From: Cleaver, Elizabeth [REDACTED]
Sent: 29 November 2019 19:44
To: Planning.Responses <Planning.Responses@arun.gov.uk>
Cc: Planning SE [REDACTED]
Subject: Highways England response: Y/103/19/DOC - Land at Street Buildings, North End Road

Proposal: Approval of details reserved by condition imposed under reference Y/49/17/OUT relating to Condition No 9 - highways works.

Planning Application No: Y/103/19/DOC

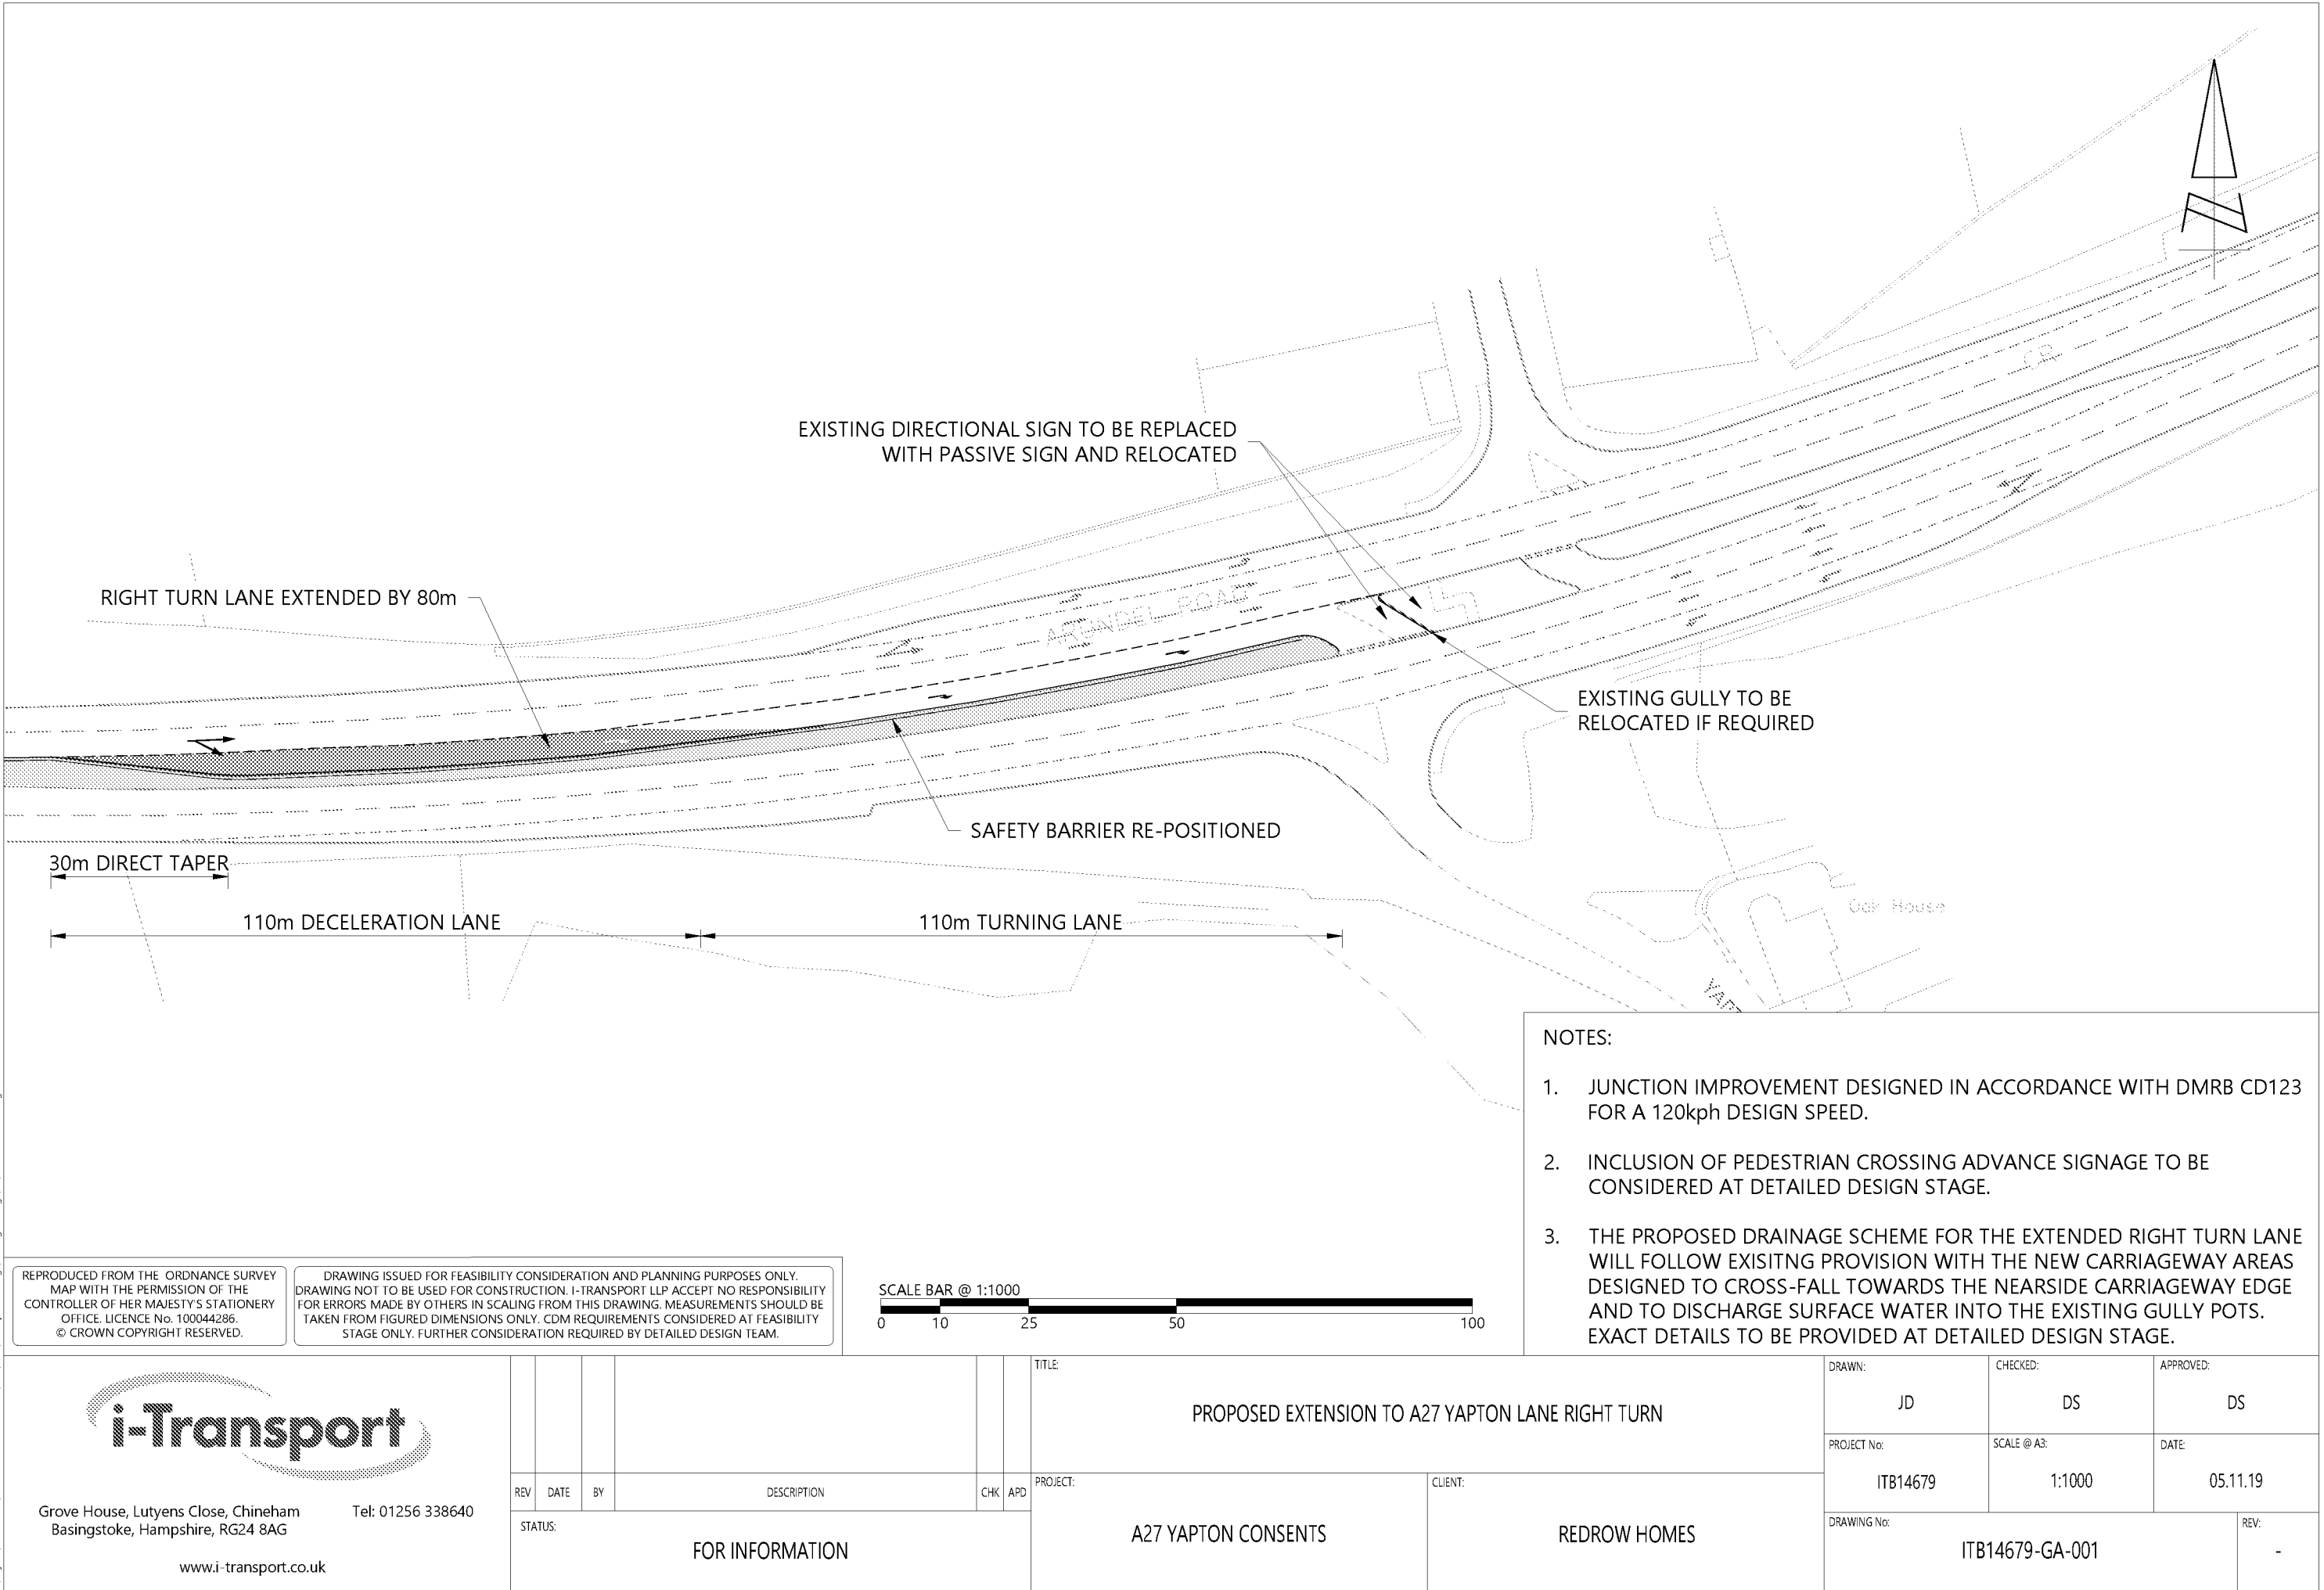
This application seeks Highways England's acceptance of the proposed junction improvement scheme in i-Transport's Drawing ITB14679-GA-001 in relation to the requirements of Condition 9 of planning permission Y/49/17/OUT. Condition 9 requires a detailed scheme of highways works, whereas drawing ITB14679-GA-001 is an outline design. We agree in principle to the outline design scheme in Drawing ITB14679-GA-001 as the basis for the detailed design scheme.

[REDACTED] so that the detailed design and section 278 improvement works can be progressed and concluded ahead of the 24th dwelling trigger point.
